City of Portland
Office of the Mayor and Council
Portland, Maine

August 2, 2004

Re: Ballpark Drive Subdivision

SHEET TITLE:	RESIDENTIAL LOT SUBDIVISION PLAT BALLPARK DRIVE SUBDIVISION
SHEET:	2 OF 10
DRAWING NO.:	2
SCALE:	1" = 50'
DATE:	NOVEMBER 22, 2004

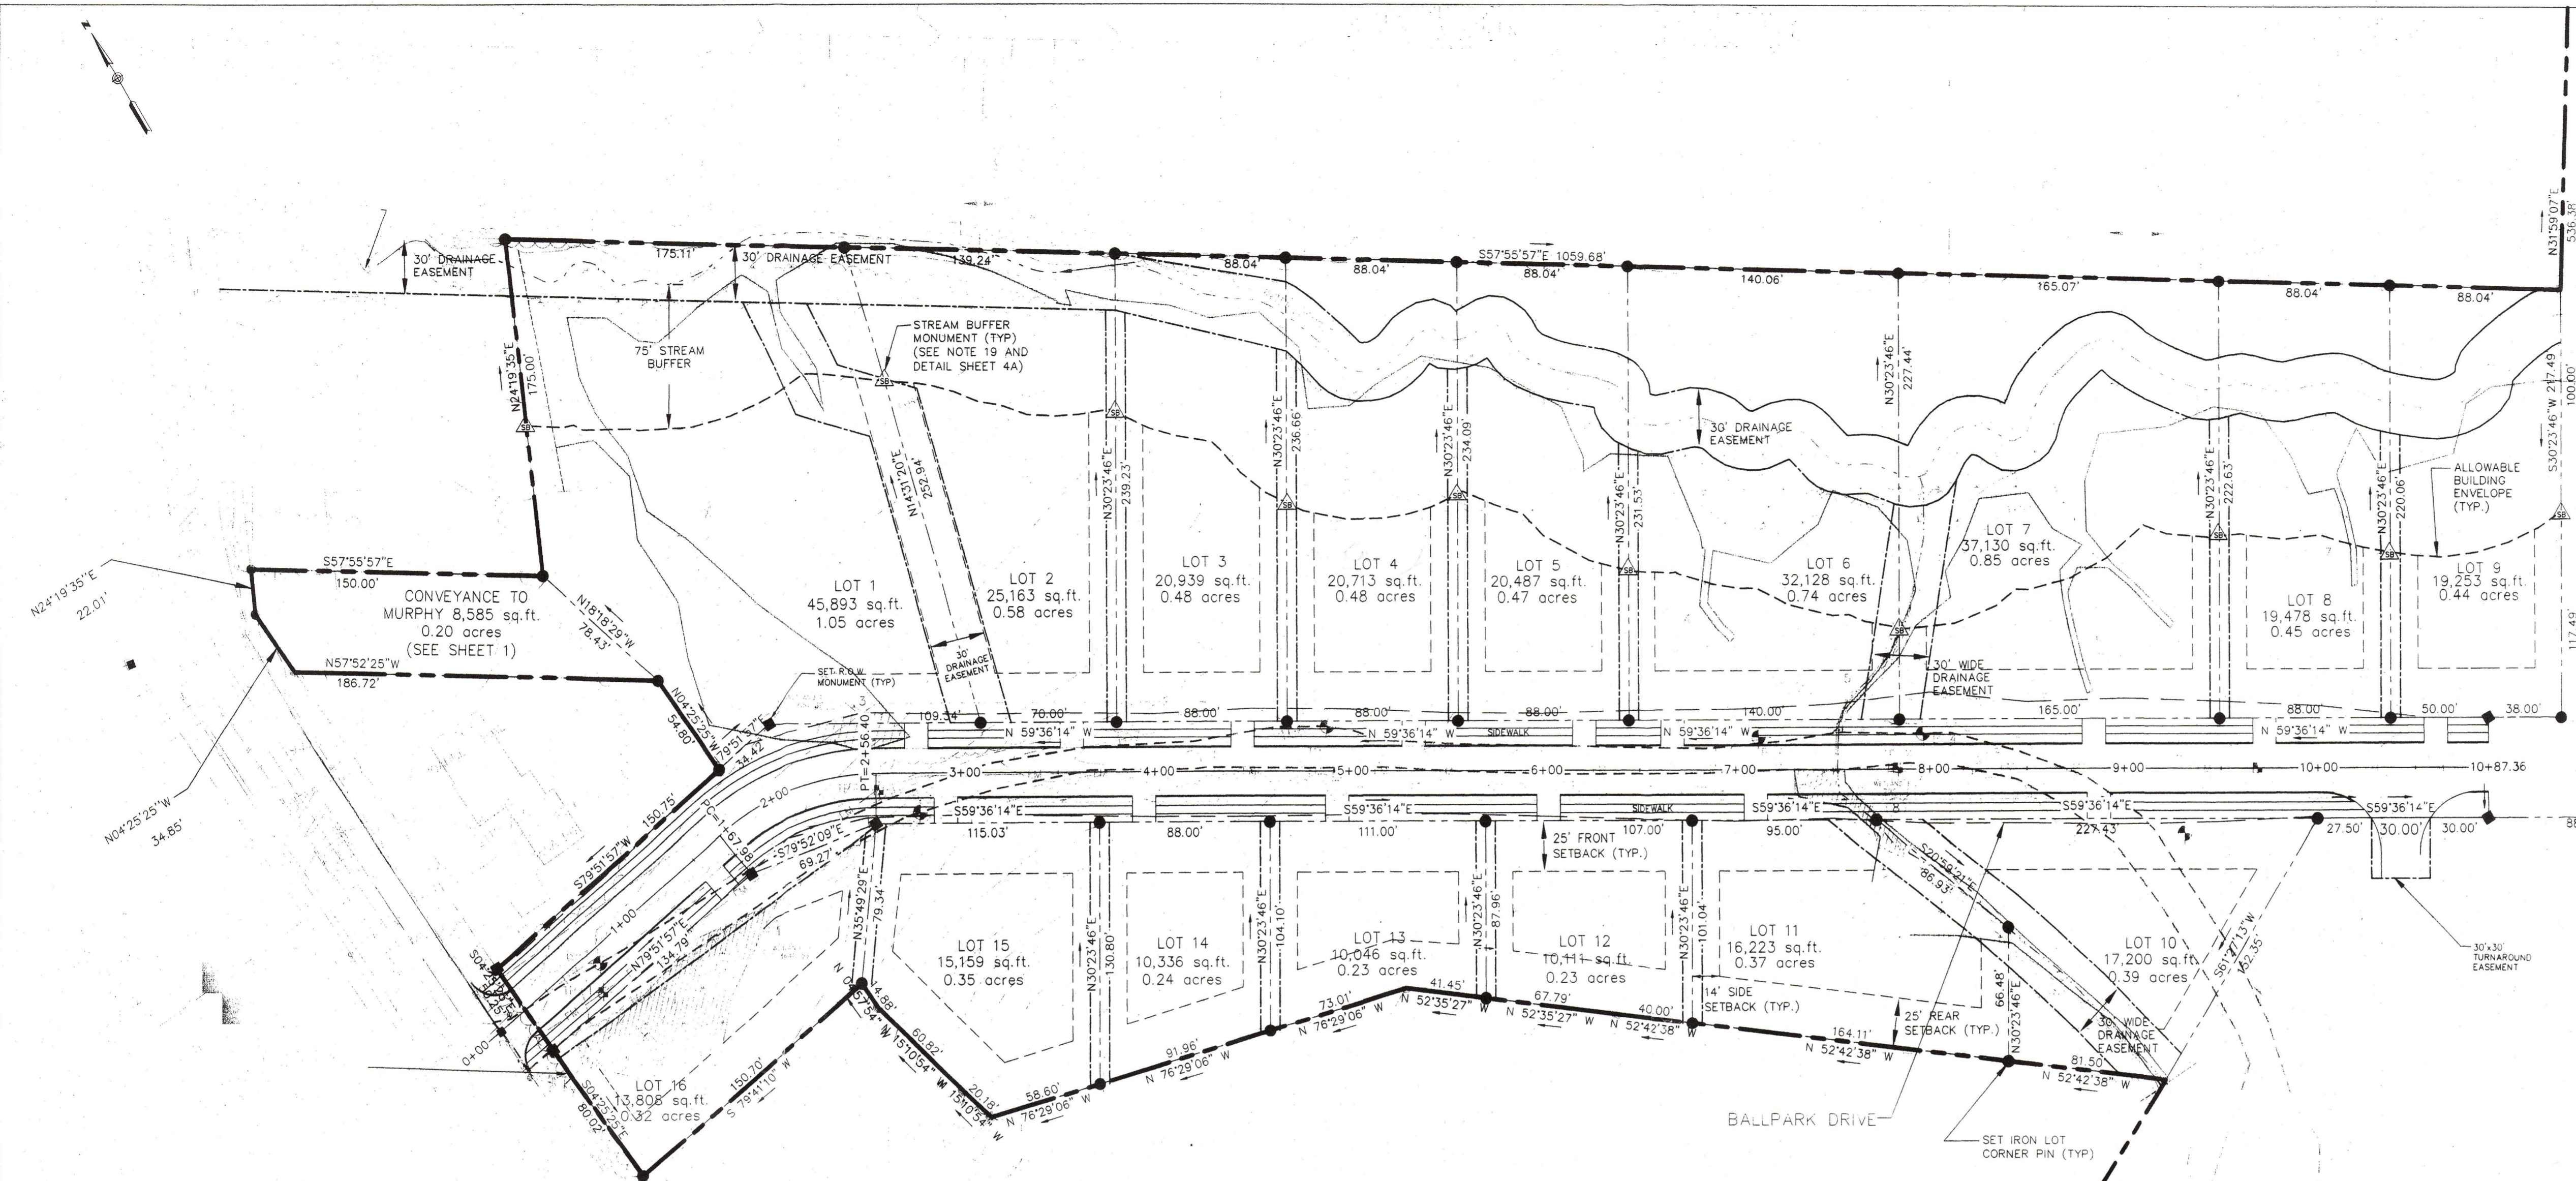
Wetland Issues. First, one of the most important elements relates to the proximity of buildings in relation to the stream that flows behind Lots 1 through 9. I understand that Staff has recommended a 75 foot setback, which I think is the minimum necessary to protect this important natural resource. That said, Lots 6 and 7 currently fall within the 75 foot buffer under the latest configuration of the plan, which is of concern. As I understand it, this configuration is caused in large part by setback requirements as measured from the proposed location of Ballpark Drive. At the Planning Board workshop, there was discussion of relocating Ballpark Drive further south, which would enable these two lots to meet the 75 foot setback. The only real obstacle appeared to be logistical, i.e. working out an easement agreement between the applicant and the City regarding a sewer force main. My hope is that the City can use all reasonable means to negotiate an easement and permit the roadway relocation so that the lots can be properly built outside the 75 foot buffer.

A second concern relates to the alignment of the building envelopes on Lots 1 and 2. Unlike the other lots on this side of the proposed street, these two lots are set back

from the road, bringing the building envelope in closer proximity to neighbors along Lester Drive. It is not clear from the site map why such an orientation is necessary, or desirable. If at all possible, I hope Staff is able to work with the applicant to locate these building envelopes closer to the proposed street.

Assuming the building envelopes can be properly configured to the minimize impact on Lester Drive neighbors, another important condition for consideration is appropriate marking of the building envelopes on the face of the earth. I see from the Planning Department packet that deed restrictions have been proposed, but I know from experience that encroachment on open space or conservation land is common without clear demarcations on the face of the earth. In fact, one need only look across the street at Lester Drive to see where this has occurred. To avoid this problem going forward, requiring visible, lasting markers of property boundaries may be a small price to pay for long-term compliance with the buffering requirements.
